Rooms in roof with hips to gables & front & rear extension
Glenian The Street East Preston

Thank you for your internet representation made on 5th April 2018 which has been recorded as '**an objection**' with the comments as follows:

I am commenting on this application on behalf of the East Preston and Kingston Preservation Society.

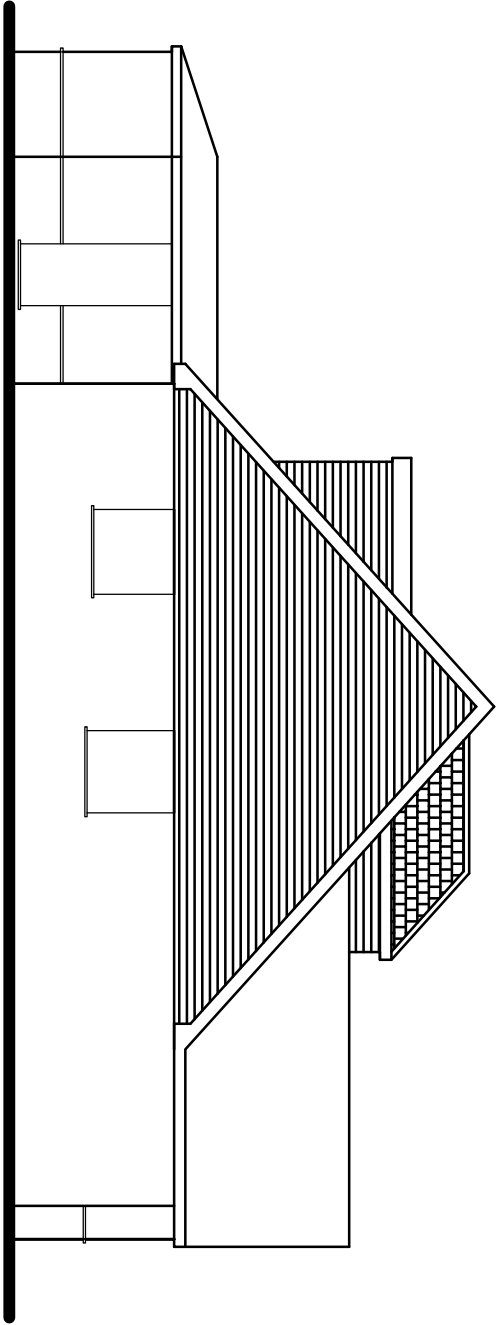
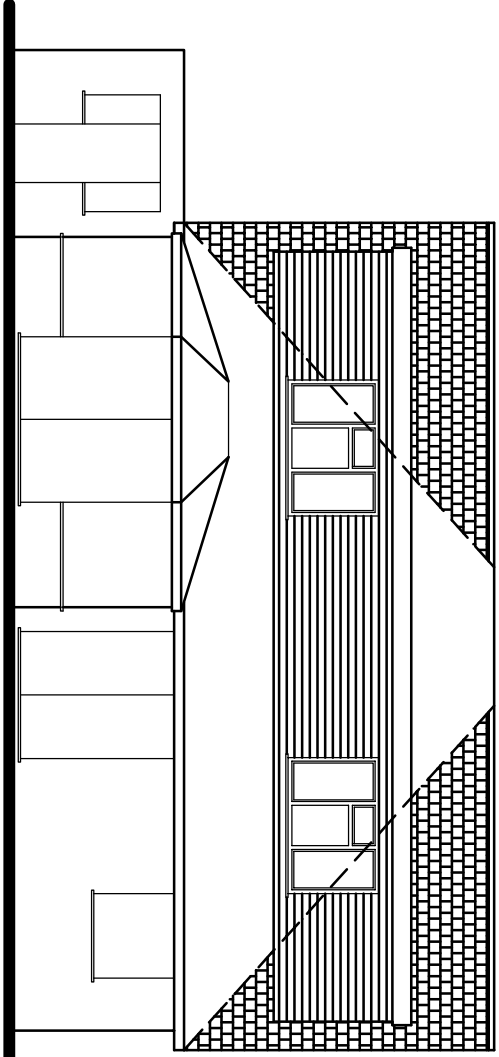
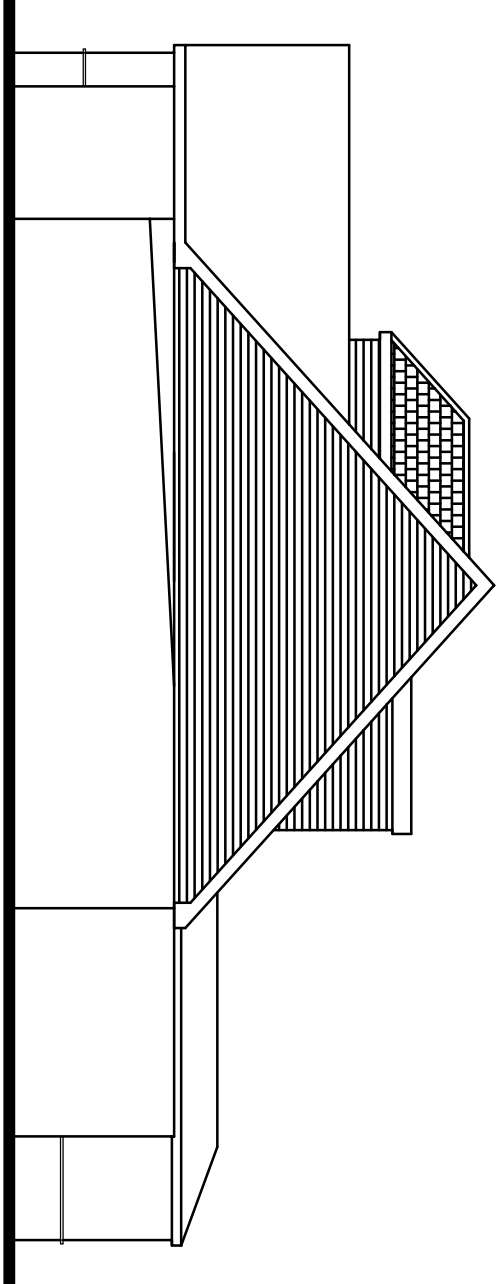
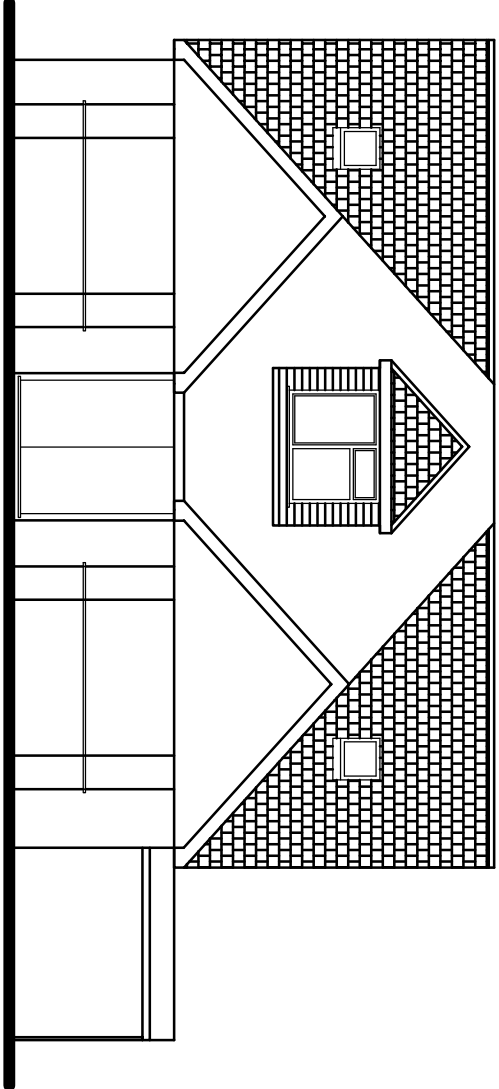
The proposal is to add a second storey to a bungalow. The bungalows north and south of Glenian are unchanged from their original design, so the alterations would produce a building that was in sharp contrast to its neighbours. It would not therefore reflect and enhance the architectural and historic character and scale of the surrounding buildings, as required by Policy 1 of the East Preston Neighbourhood Plan..

The proposed second storey would not sympathetically relate to, or be visually integrated with, the existing structure. The proposal is therefore contrary to Policy DEV19 of the Arun Local Plan. The alterations would not look as if they were part of the original design of the house, and they would produce a house that was unbalanced in appearance: the new roof and dormers would dominate the building. The proposal is therefore contrary to Policy 1 of the Neighbourhood Plan.
